**From:** Nick Howard  
**Sent:** 07 March 2018 15:07  
**To:** Planning.Responses  
**Subject:** RE: Planning Consultation on: WA/12/18/PL

**Site Address:** Shell Filling Station Arundel Road Fontwell BN18 0SB

**Description of Works:** Replacement sales building, canopy link removed, new bin store, delivery bay, front of store customer parking, replacement of condensers & 2 No new electric charging points.

TITLE : ELECTRIC CHARGING POINT

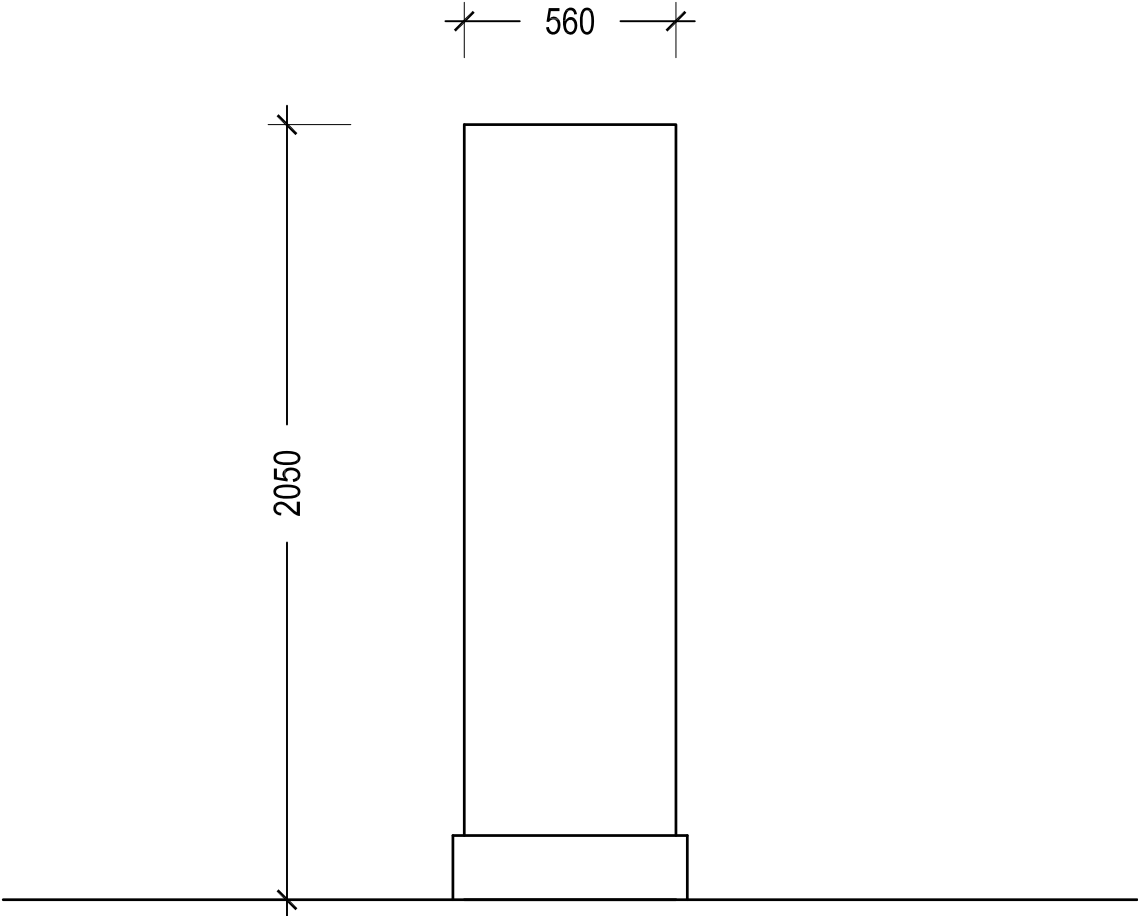
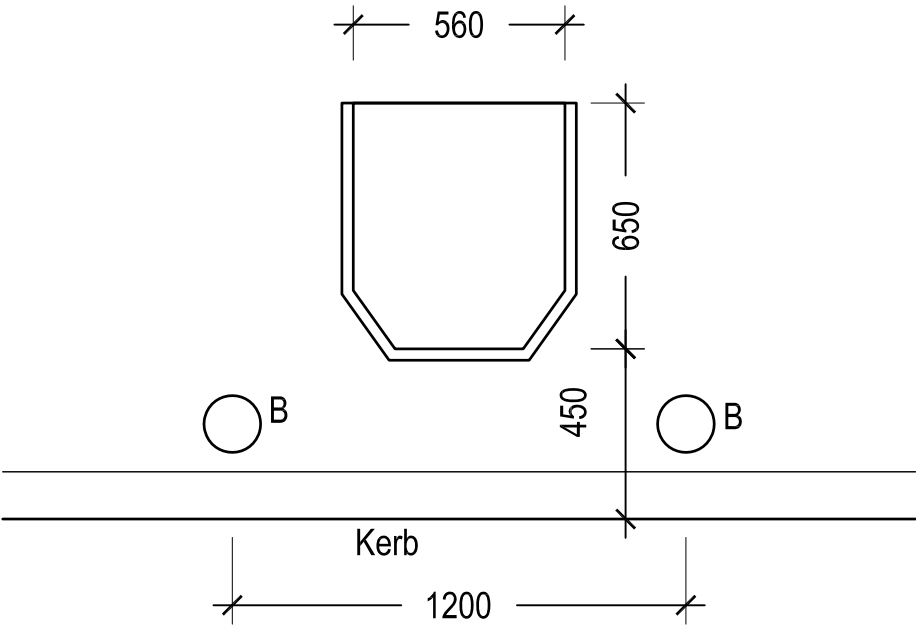
Noise from condensers and electric charging point units- has potential to cause nuisance to neighbouring properties and patrons at the travel lodge. Therefore I propose the following conditions;

16. All plant, machinery and equipment installed or operated in connection with the carrying out of this permission shall be so enclosed and/or attenuated so that the rating level of noise emitted does not exceed the background sound level, when measured according to British Standard BS4142: 2014 at any adjoining or nearby noise sensitive premises.

17. Details, including acoustic specifications, of all fixed plant, machinery and equipment associated with air moving equipment [(including fans, ducting and external openings)], compressors, generators or plant or equipment of a like kind, installed within the site which has the potential to cause noise disturbance to any noise sensitive receivers, shall be submitted to and approved by the local planning authority before installation. The rating level of noise emitted from the use of this plant, machinery or equipment shall not exceed the background sound level when measured according to British Standard BS4142: 2014, at any adjoining or nearby noise sensitive premises.
